MORGAN OFFSHORE WIND PROJECT: GENERATION ASSETS

Applicant's Response to IP submissions submitted at Deadline 2

Application Reference: EN010136

12 November 2024

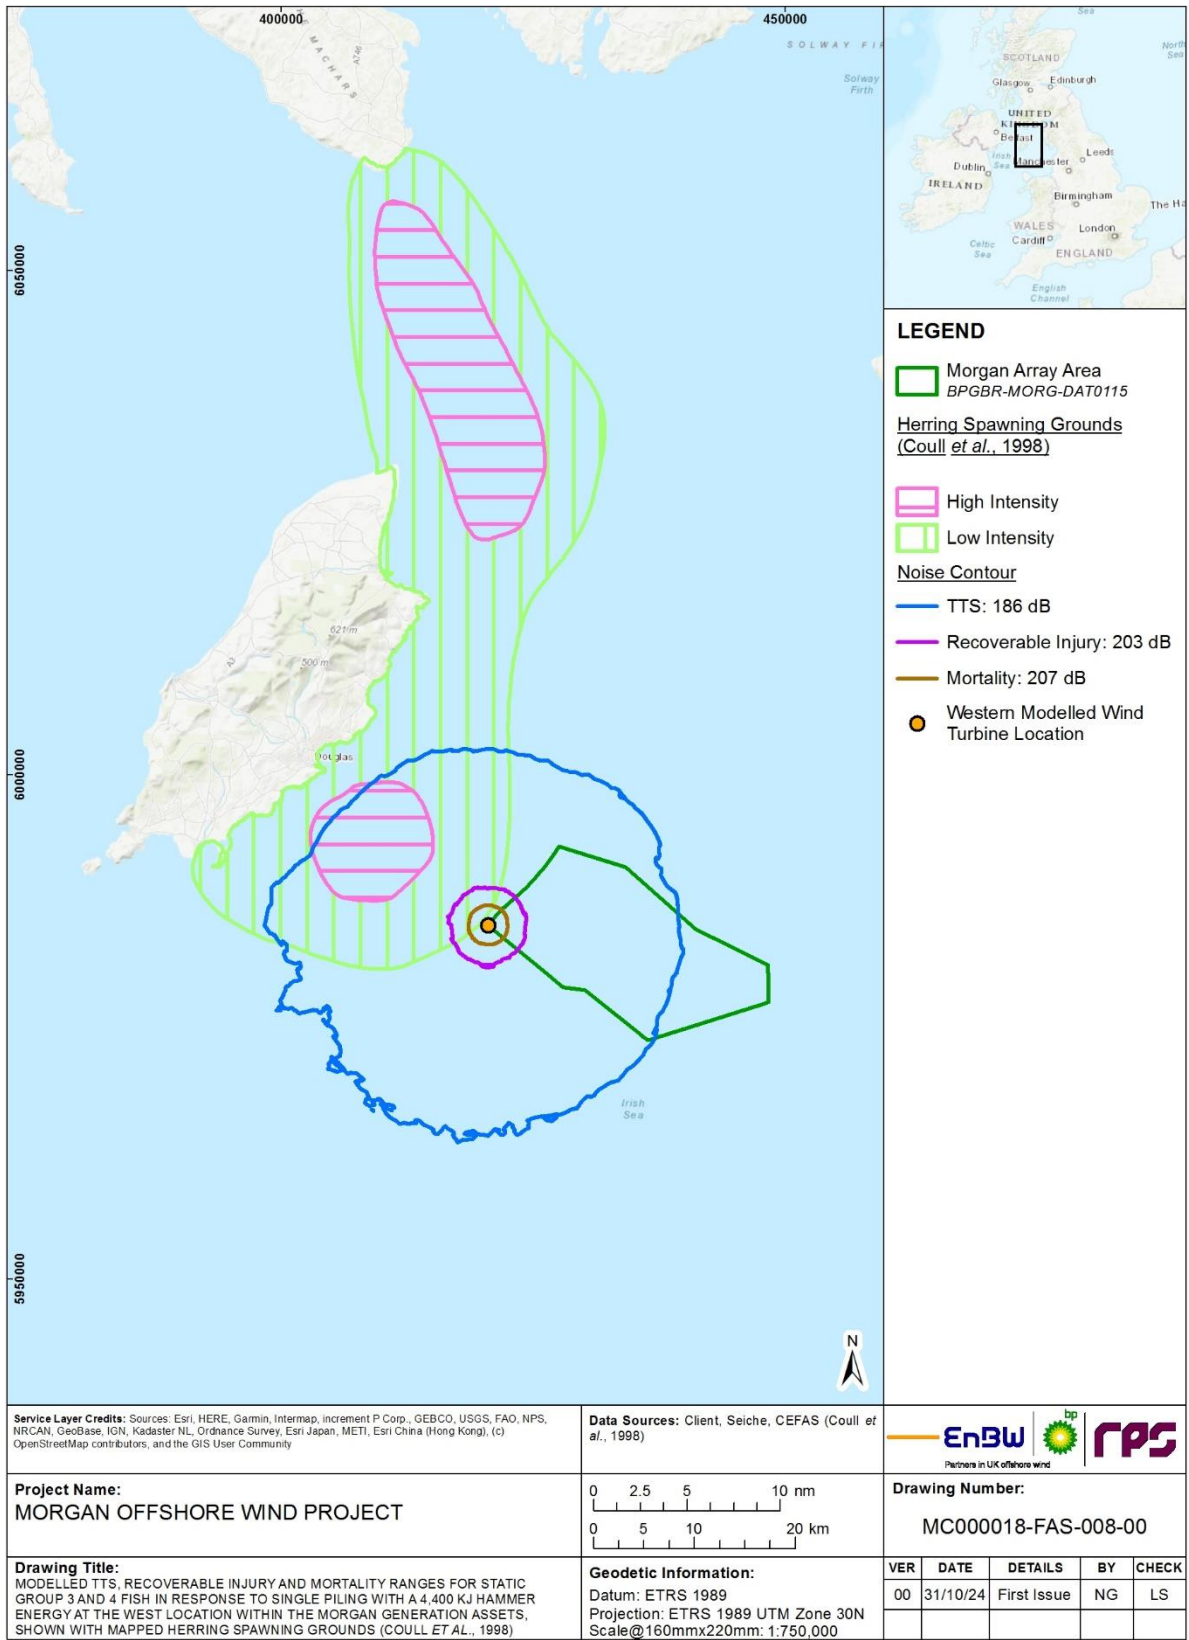
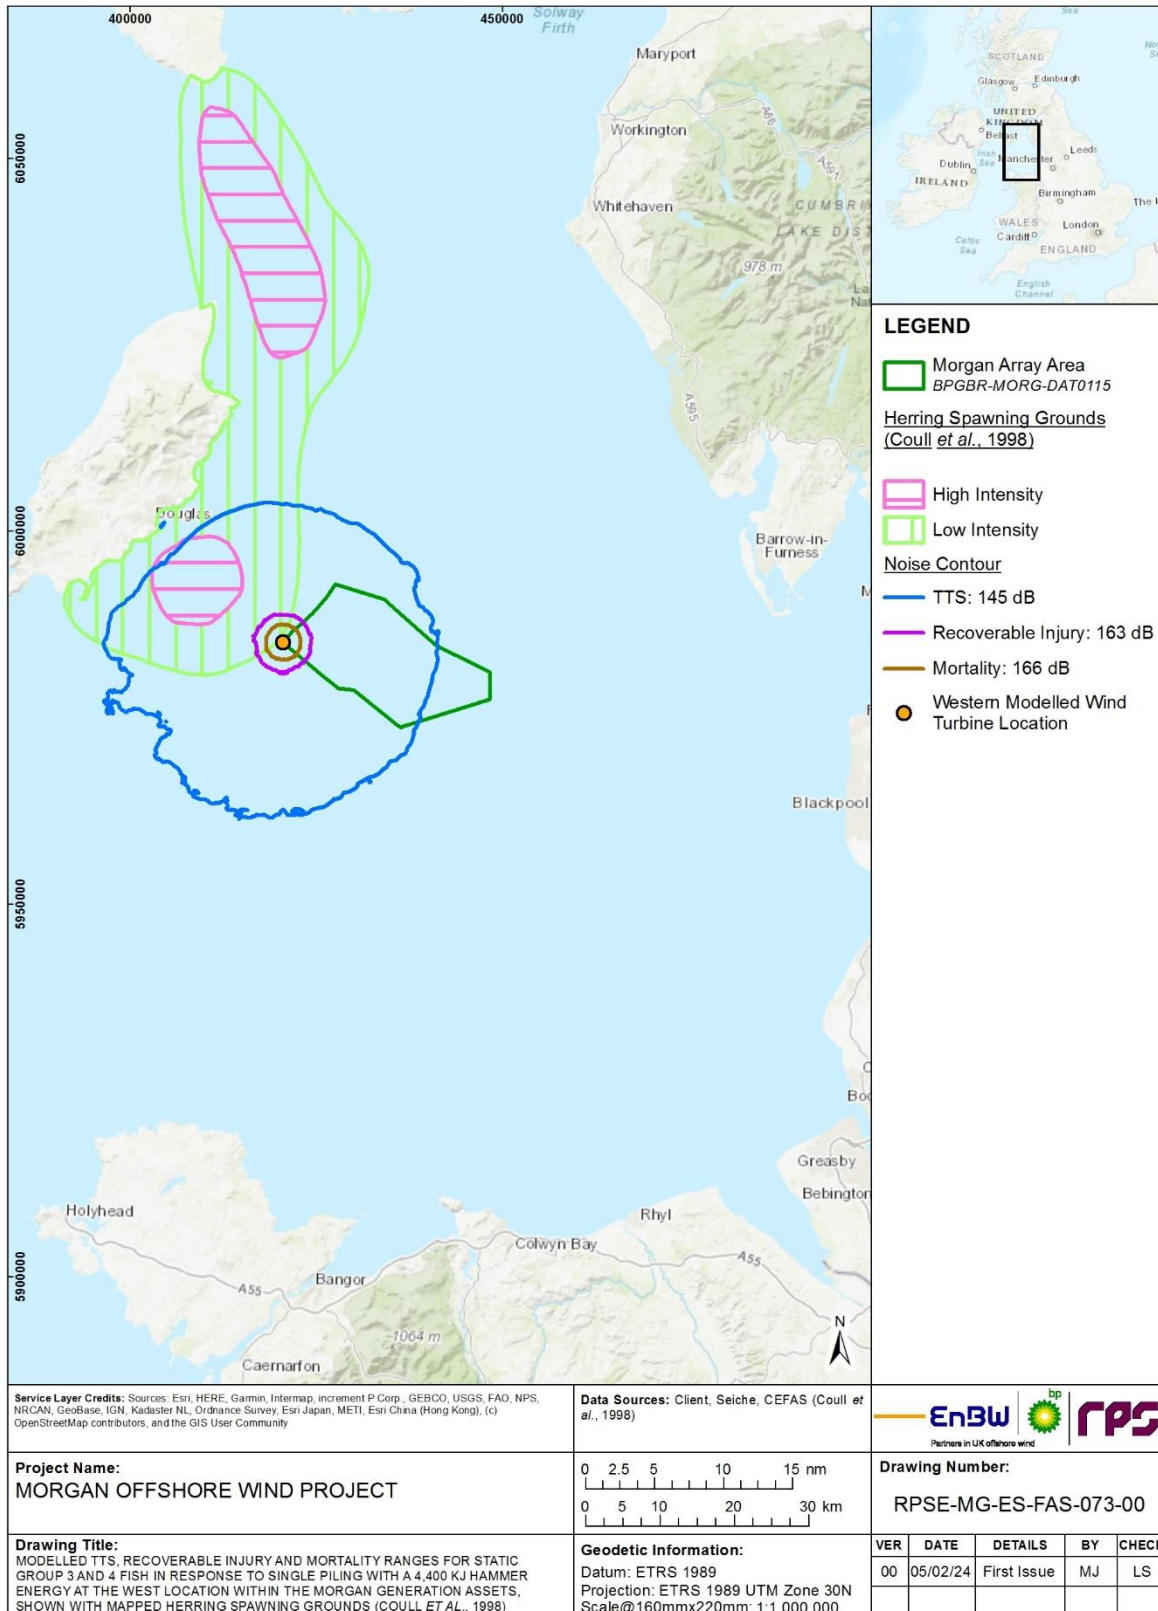
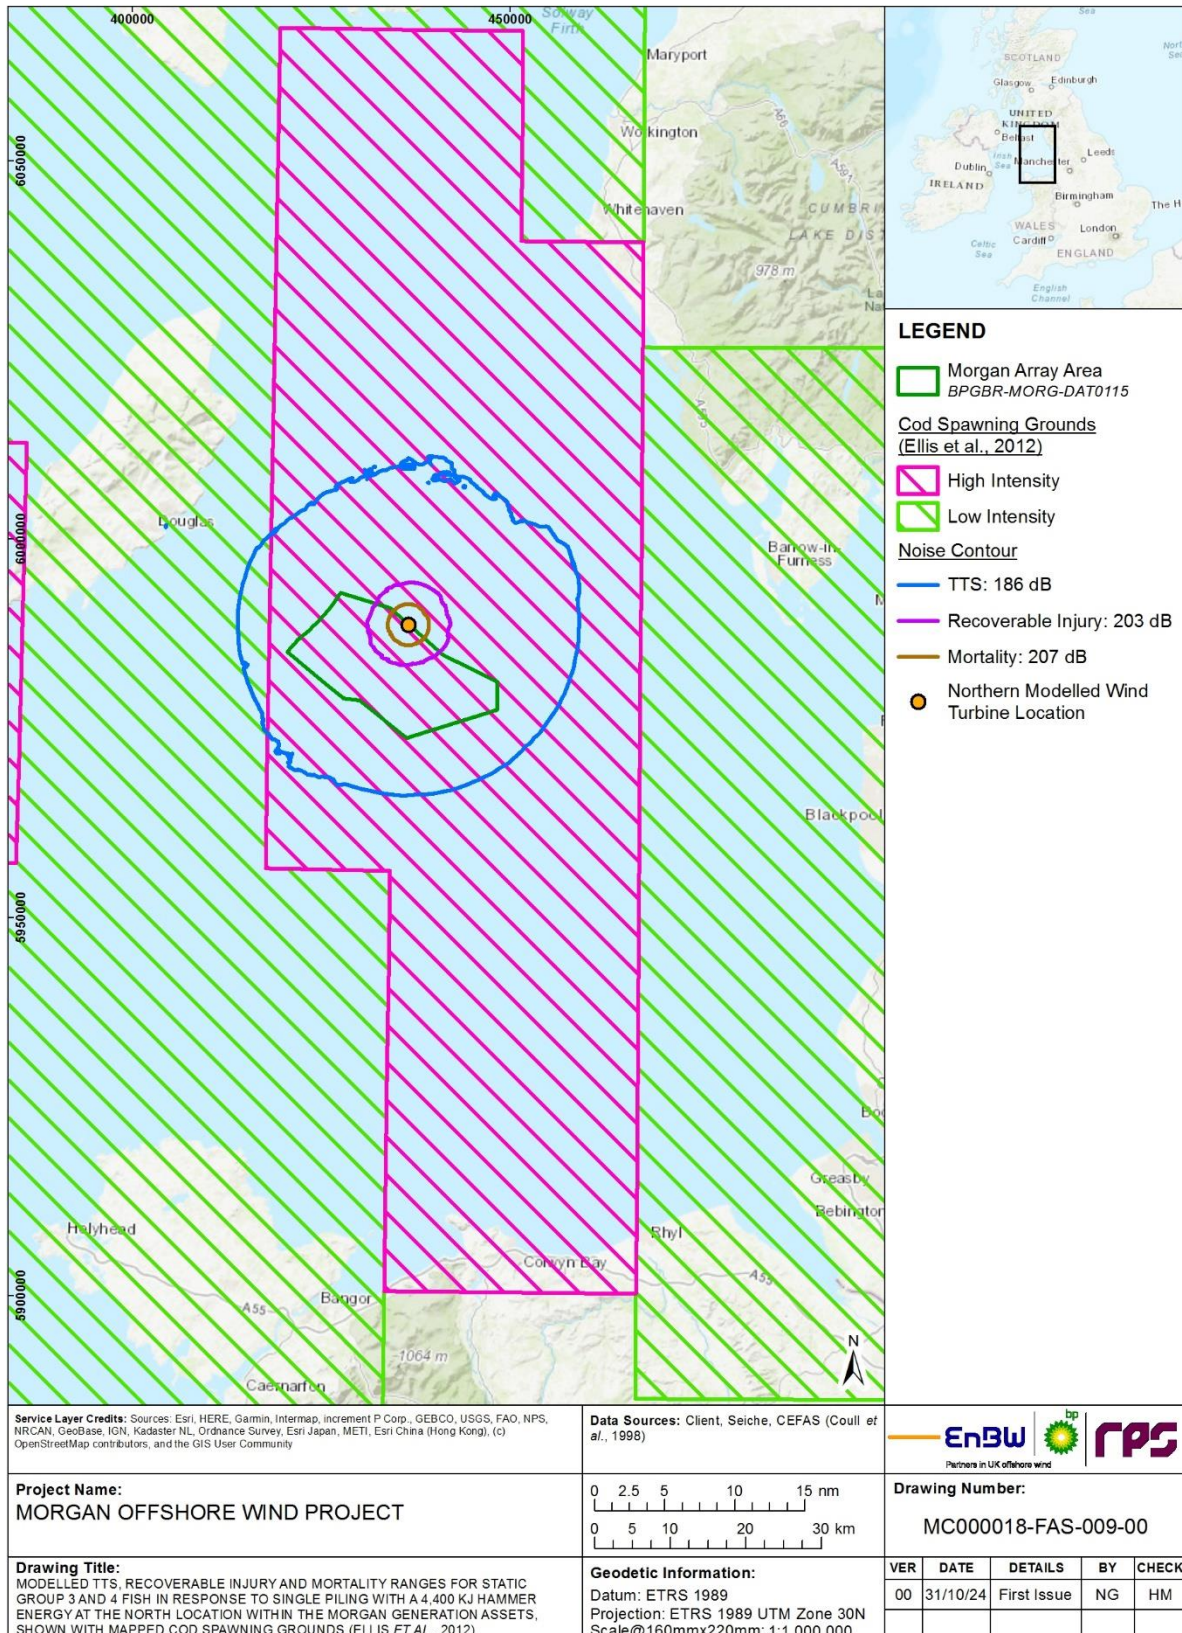
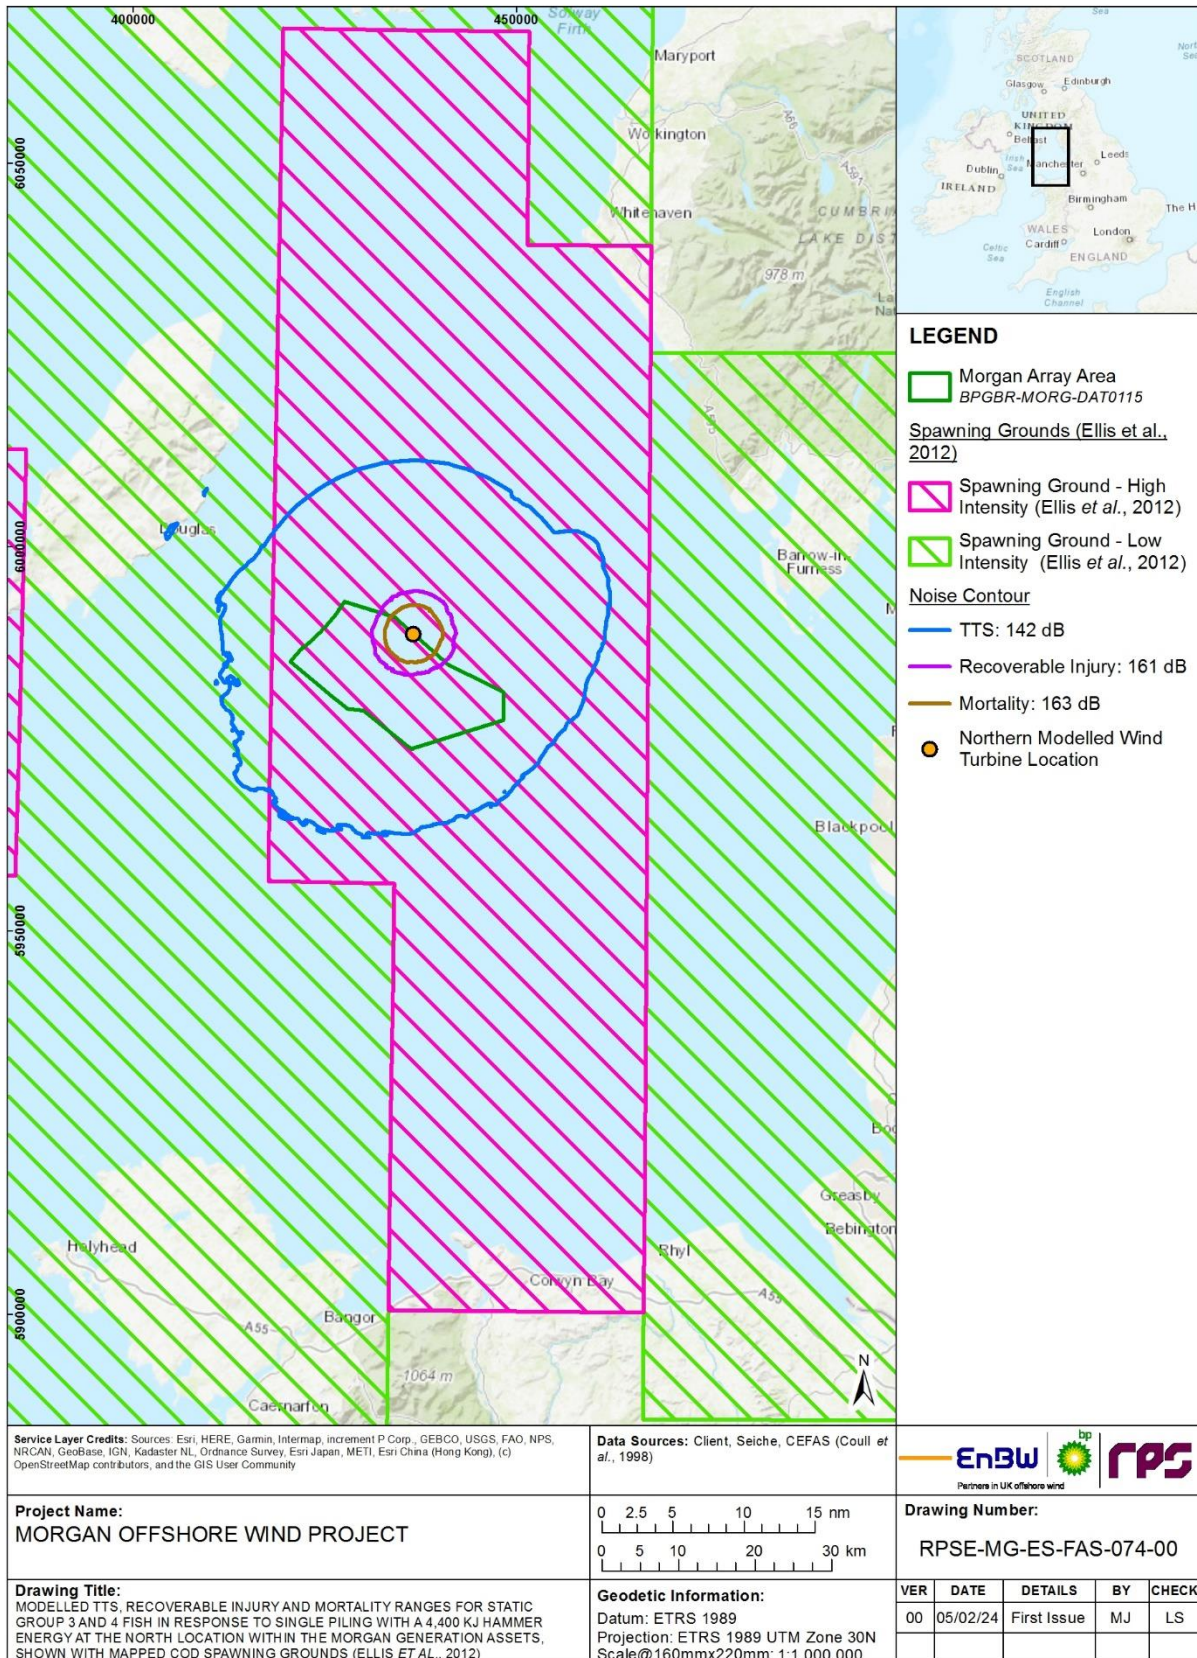
REP2-029.3	<p>1.1.3 In relation to Section 1.2.2 of Annex 3.1 which relate to the contour decibel levels presented in Figures 3.8, 3.9, 3.10 and 3.11 of the fish ecology chapter, the MMO does not agree with the approach of deriving the modelled underwater noise (UWN) contours from the</p>	<p>The Applicant notes the MMO's Written Submission and has provided updated contour plots in S_D3_3.1 Annex 3.1 to the Applicant's response to Written Representations from the MMO F01, showing contours for Temporary Threshold Shift (TTS), Recoverable Injury and Mortality for Group 3 and 4 static fish receptors in the SELcum metric. These contour plots are less conservative than those used for the fish and shellfish underwater sound assessment [APP-021] and showed a slight</p>

Reference	Written Submission at DL2	Applicant's response
	<p>SELs metric to provide a visual representation of the relevant SELcum thresholds. Please refer to response RR-020.55 in Table 1 for further details.</p>	<p>decrease compared to the original assessment, but the areas affected have not significantly changed overall and therefore the assessment conclusions remains the same.</p>
<p>REP2-029.4</p>	<p>1.1.4 In relation to Section 1.2.3 of Annex 3.1, the MMO thanks the Applicant for clarifying that the UWN contours presented in Figure 3.14 of the fish ecology chapter display single point piling for a hammer energy of 3,000 kJ to demonstrate the behavioural ranges associated with this lower hammer energy which will represent the maximum hammer energy at 75% of piling. The MMO notes that the Applicant also highlights UWN contours for the behavioural range of impact in cod at their spawning grounds associated with the maximum hammer energy (4,400 kJ) are presented in Figure 3.5.</p>	<p>The Applicant notes the MMO's Written Submission regarding provision of underwater sound contours relating to behavioural ranges for the lower hammer energy of 3,000 kJ, along with those for the maximum hammer energy of 4,400 kJ. No action is required by the Applicant.</p>
